**Ribble Valley Borough Council**

## **DELEGATED ITEM FILE REPORT - REFUSAL**

<b>Application No:</b>	3/2015/0245/P
<b>Site:</b>	Wolfen Lodge, Fish House Lane, Chipping, PR3 2GR
<b>Development Proposed:</b>	Proposed side extension
<b>Target:</b>	21 <sup>st</sup> May 2015

plan amended 23-03-15  
dimensions added in response to request  
from Development Control

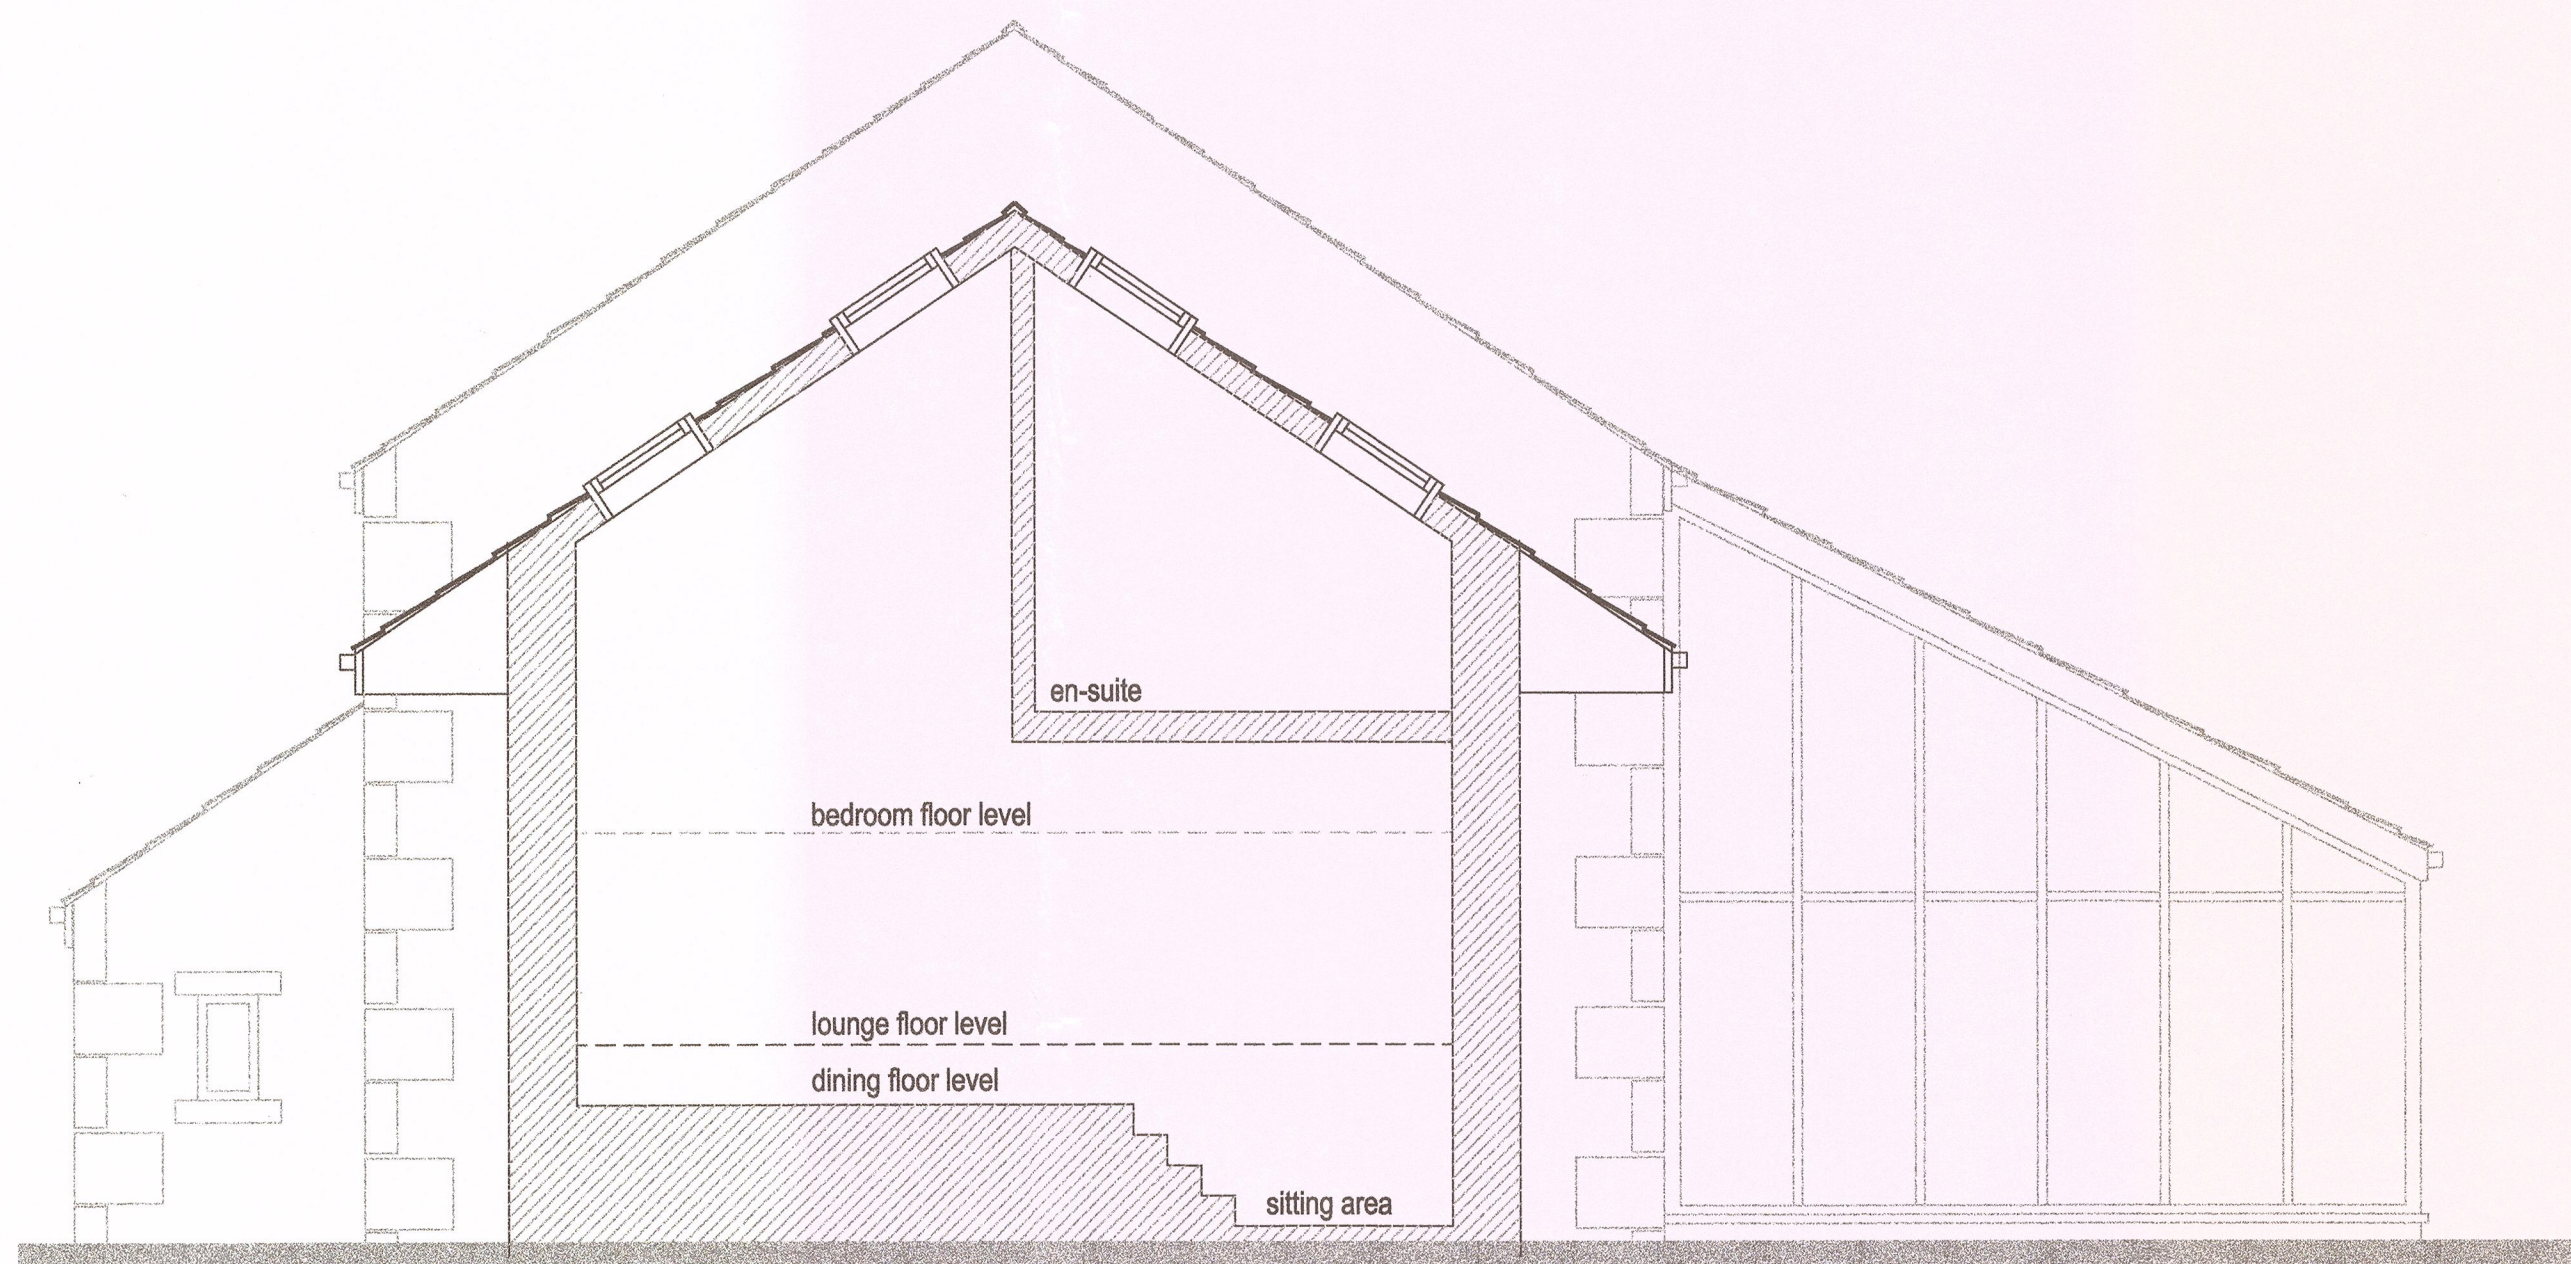
The proposed extension would project from the north gable of the existing building and would measure around 11m x 8.6m. It would have gable roof running parallel with the main roof and would have an eaves height of 2.5m and a ridge height of 5.75m. The addition would provide additional lounge, dining and sitting areas and would include the introduction of an internal flue at the north end of the extension. The proposed development would be to the side of the existing property and would not be visible from long-range. However, it would be visible from Fish House Lane and public footpath no.110 which passes along the front of the site.

In relation to its scale and form, the extension would have lowered eaves and ridge compared to the main building and would be set back from the front and rear walls at the point it joins the gable elevation of Wolfen Lodge. However, the proposed development would have a void over the proposed living area resulting in a height of around 7m at the point it would join the main building and would have a height equivalent to a 1 ½ storey building. Furthermore, the depth of the extension increases to the north to reflect the width of the main building. The extension would increase the length of the property to 28m leading to a significant increase in the scale and mass of the building. It is considered that the proposed extension would not be clearly subservient to the main building and would be a bulky and incongruous addition that would substantially increase the mass of the host property. Additionally, whilst the extension would continue the linear form of the building, it would complicate the simple front elevation of the property and would unbalance the building due to massing to the north side.

Agricultural buildings are characterised by a limited number of window and door openings. Nonetheless, it is noted that the conversion of the agricultural barn has resulted in the creation of a number of additional window and door openings creating a somewhat ordered and symmetrical fenestration of the existing building. The proposed extension seeks to introduce large timber framed glazed elements to the front, rear and gable elevation and a number of roof lights to the front and rear roof slopes. This would be neither in keeping with the original building or the building as it stands today and would not respect the existing ratio between solid wall and window. These proposed openings do not sit comfortably with the building, would not reflect local vernacular or style and devalue the character of the traditional farm building and that of the surrounding environment.

The property lies adjacent to open water and woodland which is ideal bat foraging habitat. The Council's Countryside Officer has stated that the provision of three roosting features within the build of the extension would comply with NPPF and Core Strategy requirements for the net gain of biodiversity. The applicant has submitted details of three Swegler bat tiles on the east and west facing elevations of the extension which are considered acceptable.

In conclusion, the proposed extension, by virtue of its massing and design, would devalue the character of this traditional farm building and that of the surrounding environment. The extension is considered to be wholly insensitive to the original form of this traditional barn and its character, appearance and historic significance. Moreover, if allowed the development would set a dangerous precedent for the acceptance of similar unsympathetic extensions destroying the character and appearance of other barn conversions which would be both contrary to Policies DMG1, EN2, DME4 and DMH5 of the Ribble Valley Core Strategy.
